**Consultation Response from KC,  
Trees**

**2025/93184 17, Birch Park, Brockholes, Holmfirth, HD9 7BJ**

**Erection of first floor extension to side, part two storey and part single storey extension to rear including balcony, associated internal remodel and landscaping works**

**Date Responded: 10/12/2025**

**1 Proposed Site Plan.**  
1 : 100

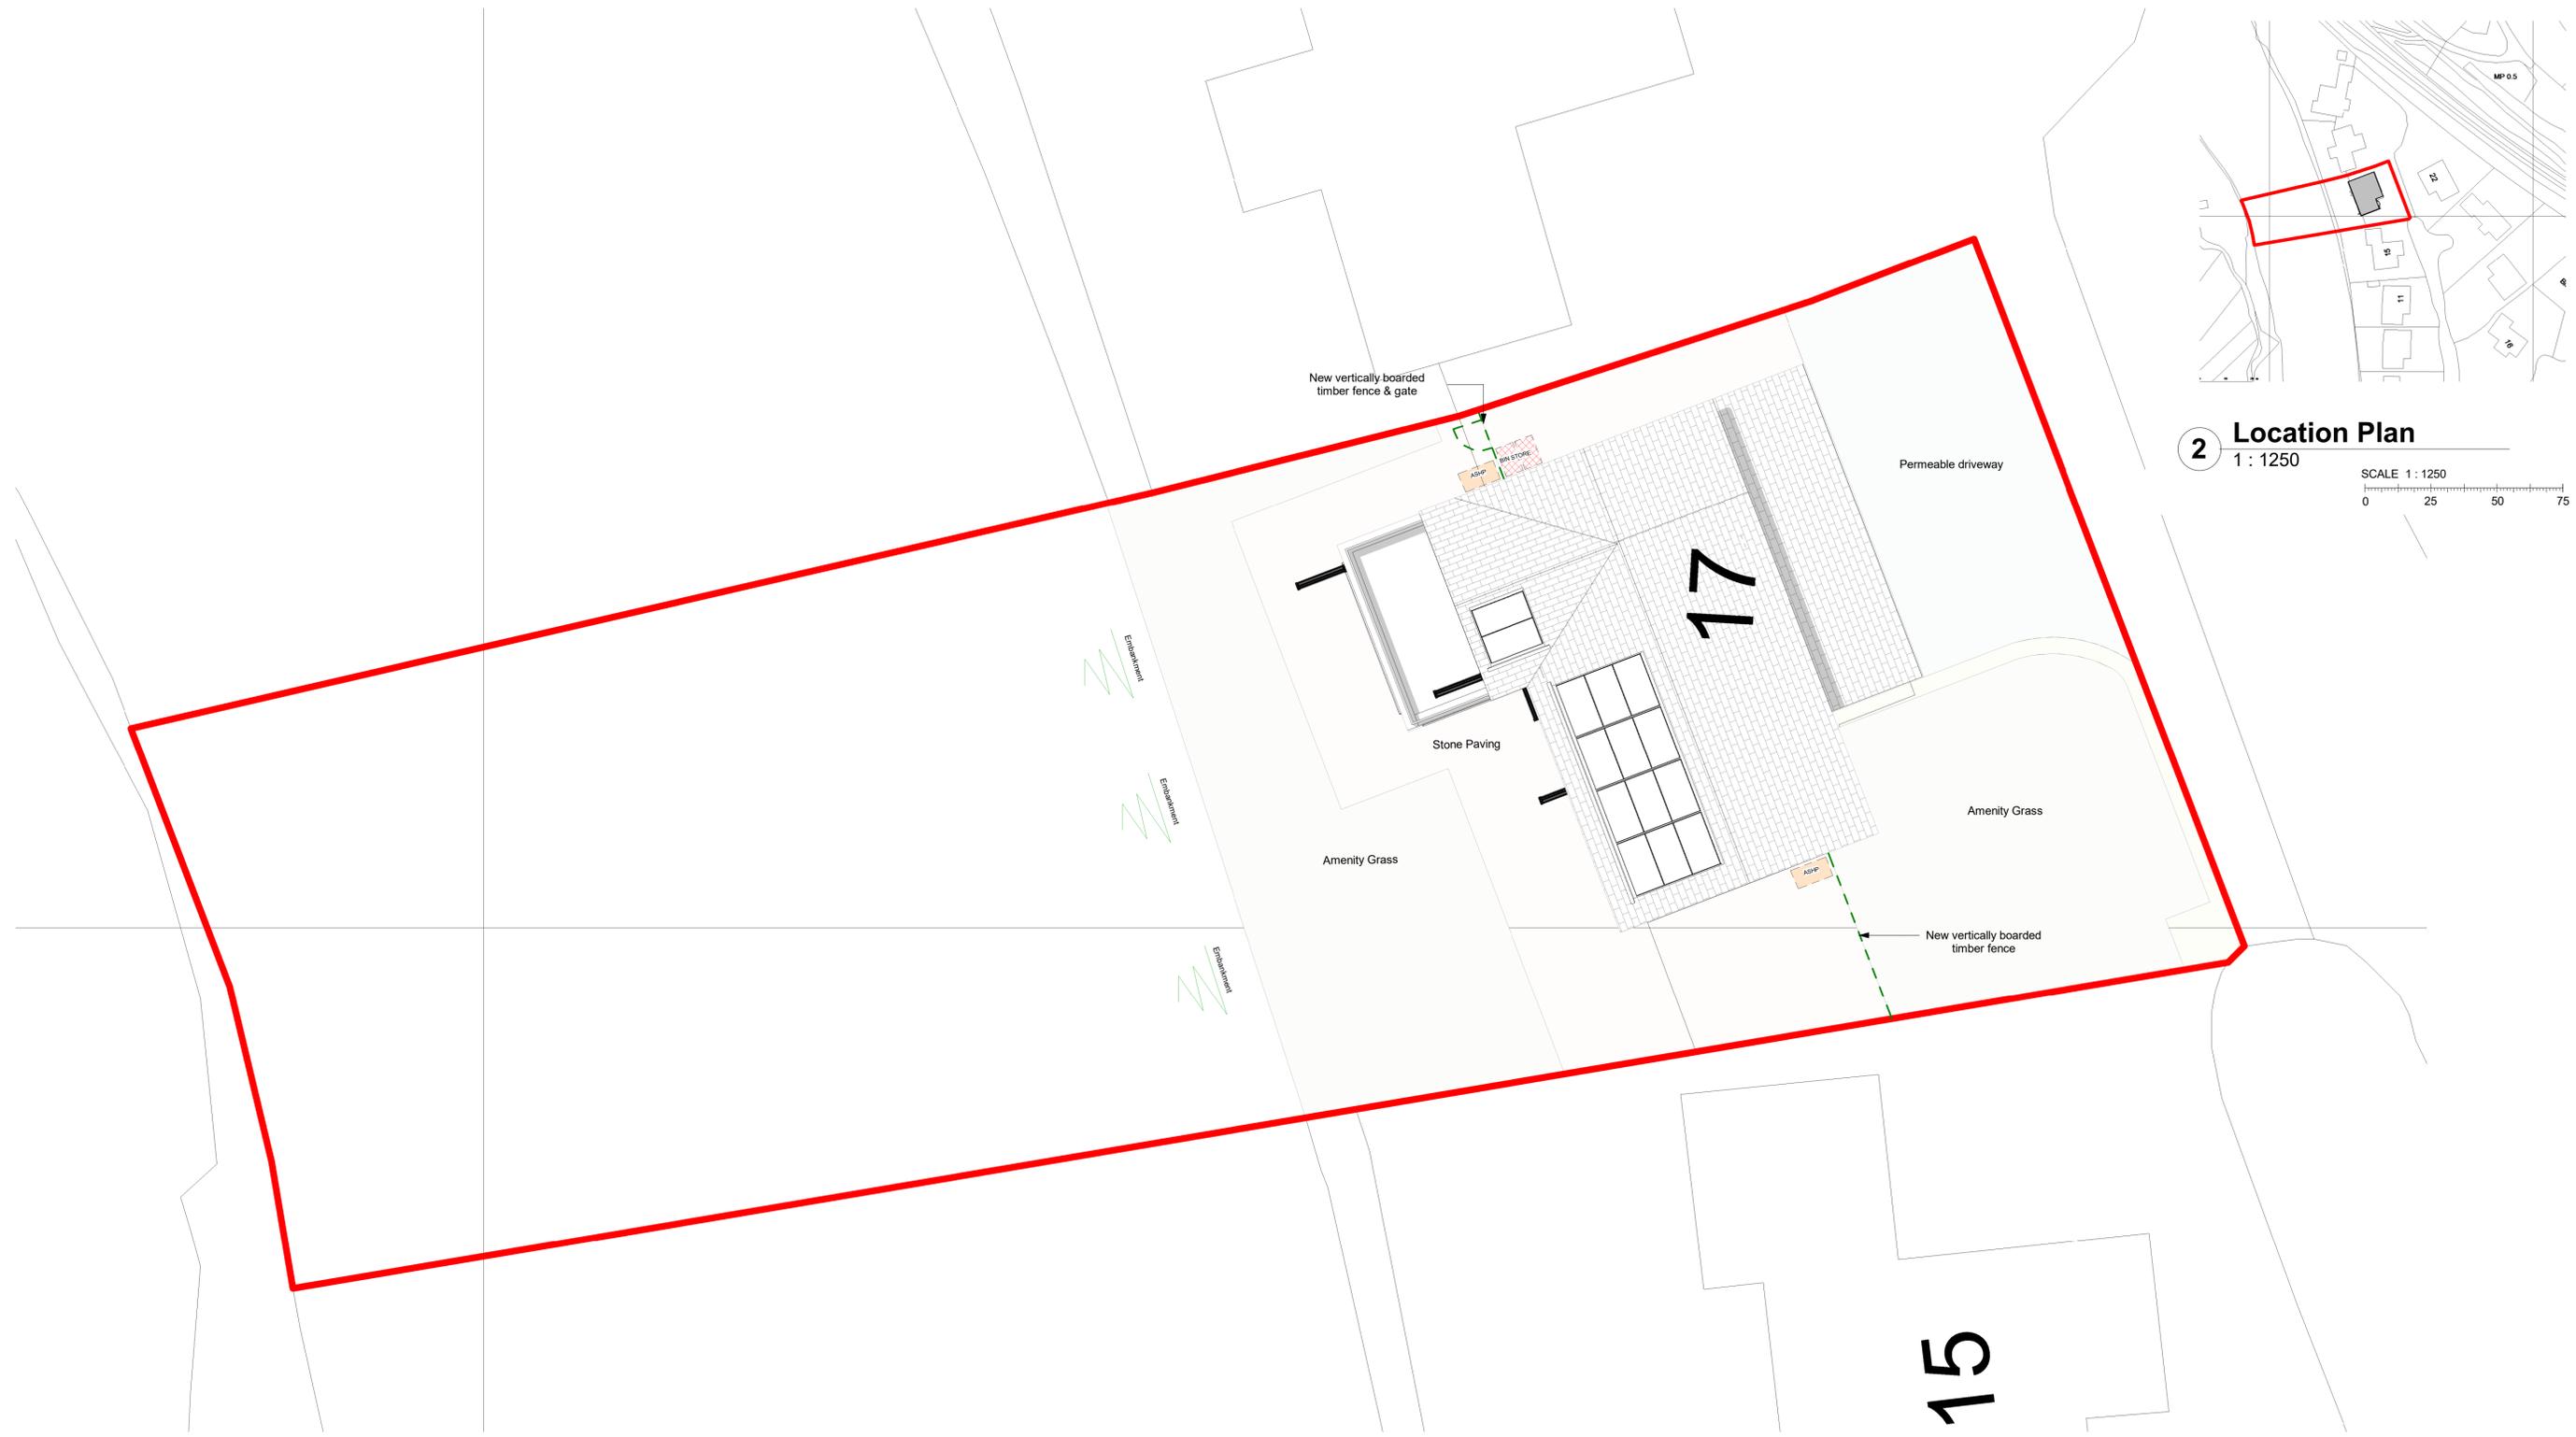
The proposed plan protrudes from the building in the direction of protected trees to the rear of the property. Due to the close proximity to protected trees there would need to be an Arboricultural Impact Assessment (AIA) submitted so that the neighbouring trees Root Protection Area's (RPA's) can be calculated and if any impact is present to these trees.

The proposals look to be achievable but the AIA will show whether any special engineering would be required should the proposals protrude into any RPA's.

For the above reasons there is a holding objection until the requested documents are submitted.
